Recommendation Report for Planning Permission

REF NO: LU/355/13/

LOCATION: Chauffeur Taxis Ltd
135A Wick Street
Wick Littlehampton

PROPOSAL: Build additional storey to create a two bedroom flat, on top existing single storey building. Thereby creating additional dwelling on the site with access via external staircase to rear. Slight amendment to previously approved ground floor flat - Resubmission of LU/185/13

Drawing Title
Extension Scheme
Proposed Plans

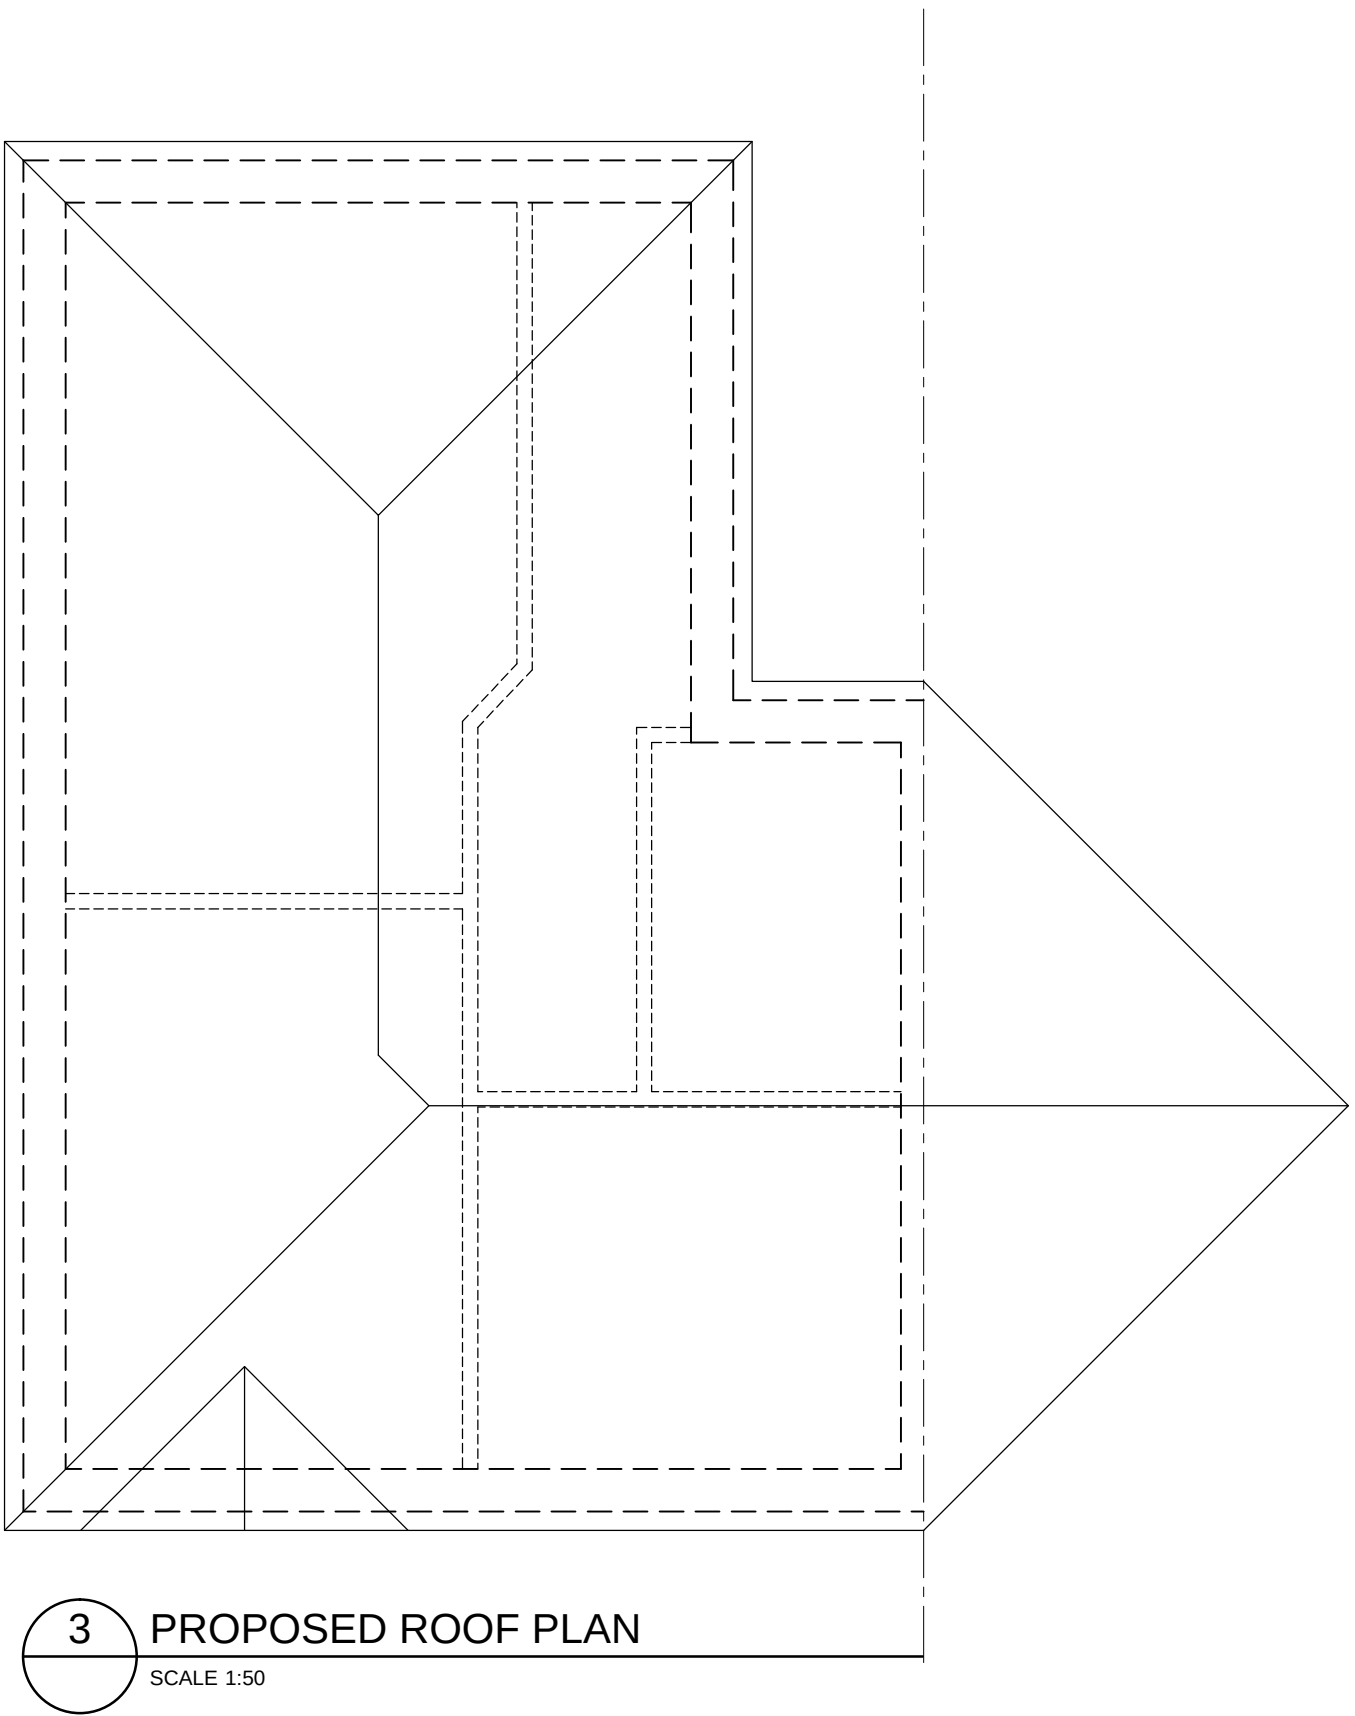
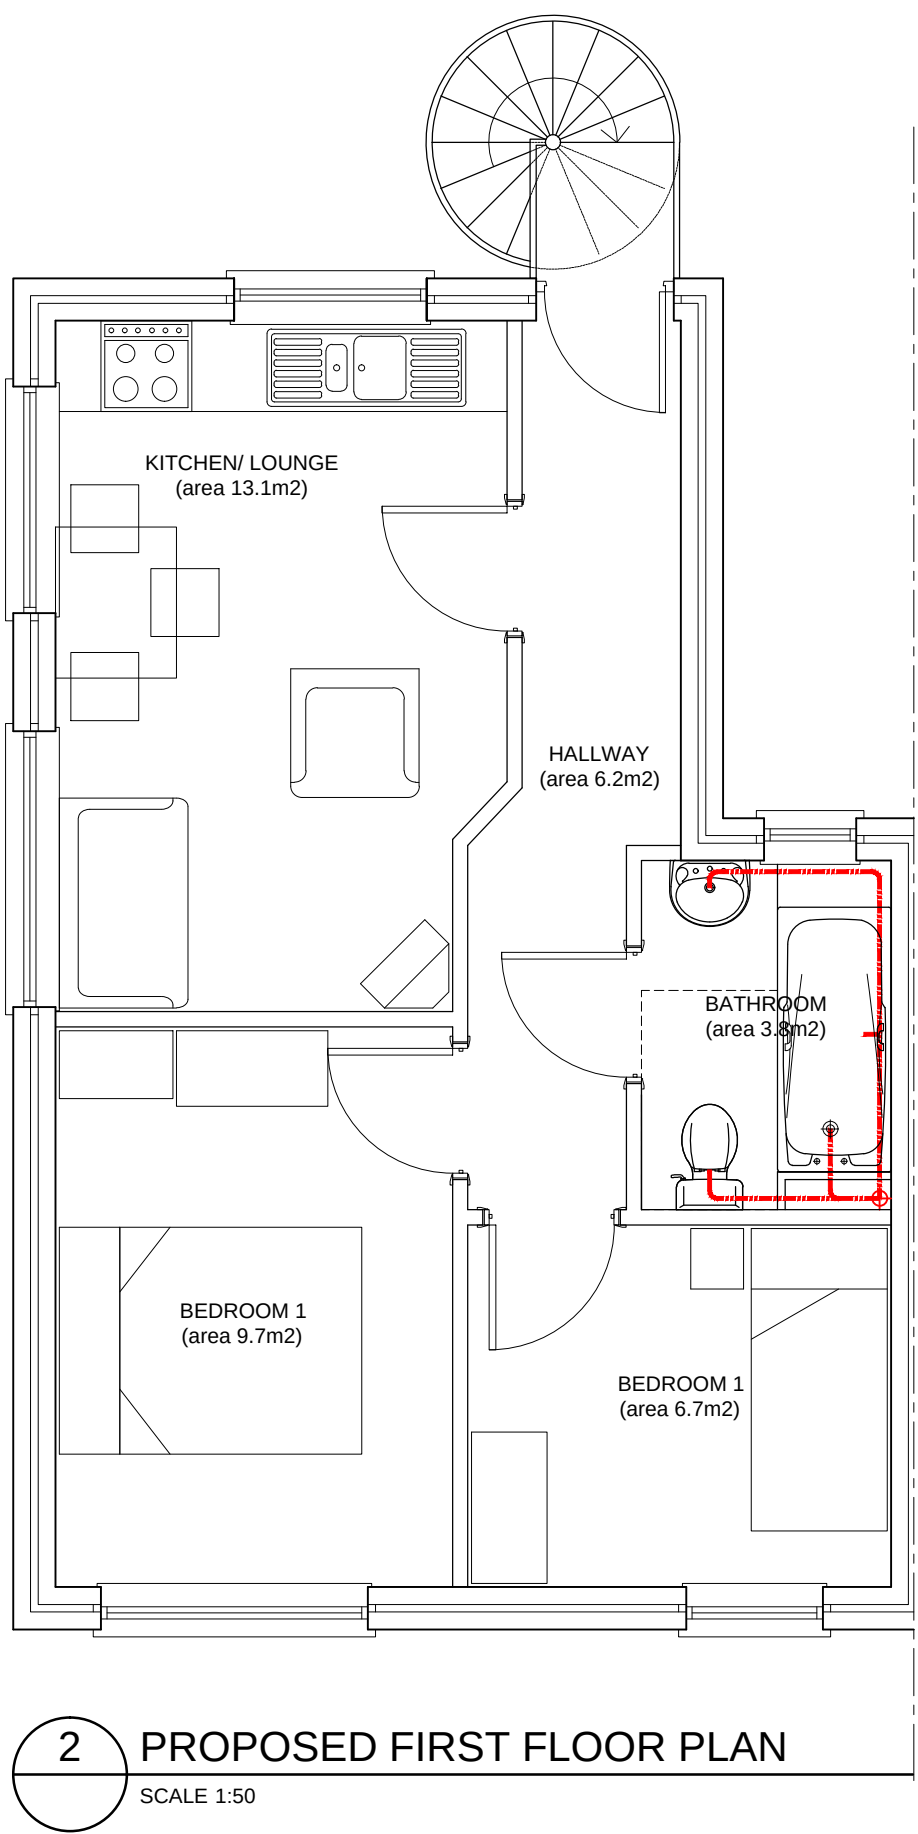
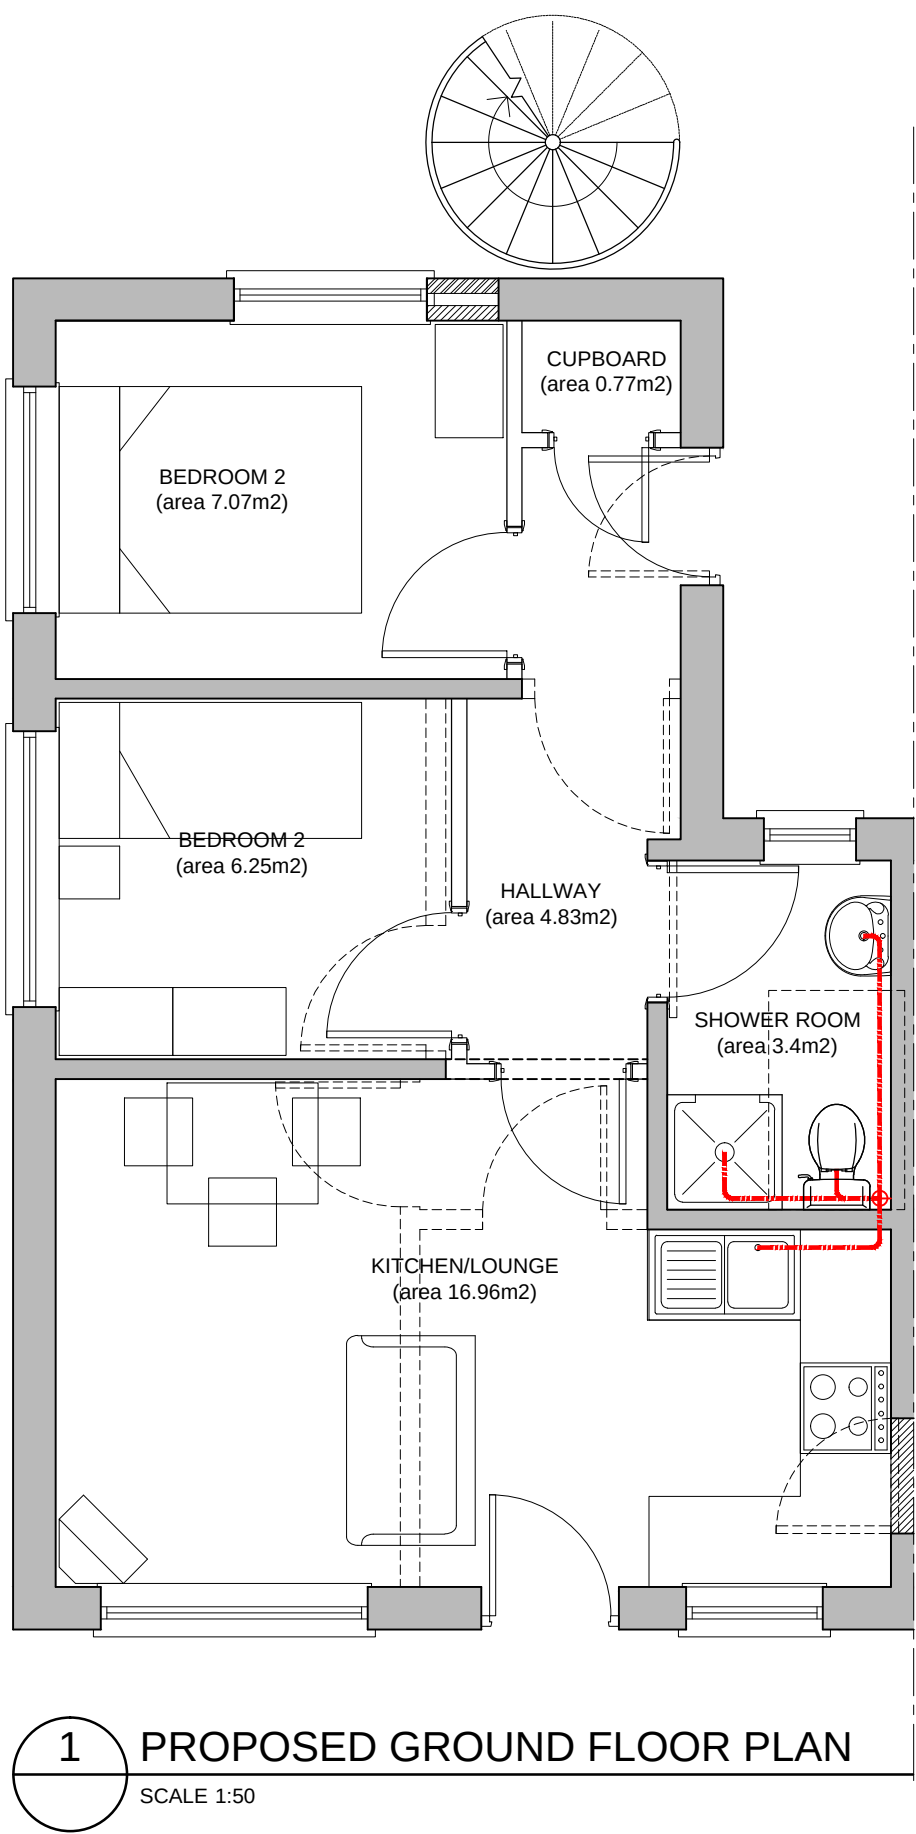
The internal layout does not accord with the Internal Space Standards set out in Policy D DM2 of the Emerging Local Plan for all proposed room sizes. The applicant has submitted a subsequent plan where only one bedroom is proposed but the kitchen/lounge still falls short of the combined kitchen/living/dining requirement by 6.4 square metres. This subsequent plan has therefore not been accepted and means that the scheme cannot be successfully accommodated on the site without conflicting with internal space standards.

- 2 Having regard to the size of the rooms, the extension would give rise to an unsatisfactory environment for the occupiers in conflict with policy GEN7 of the Arun District Local plan and policy DDM2 of the Publication Version of the Emerging Arun District Local Plan (February 2014) and the National Planning Policy Framework.
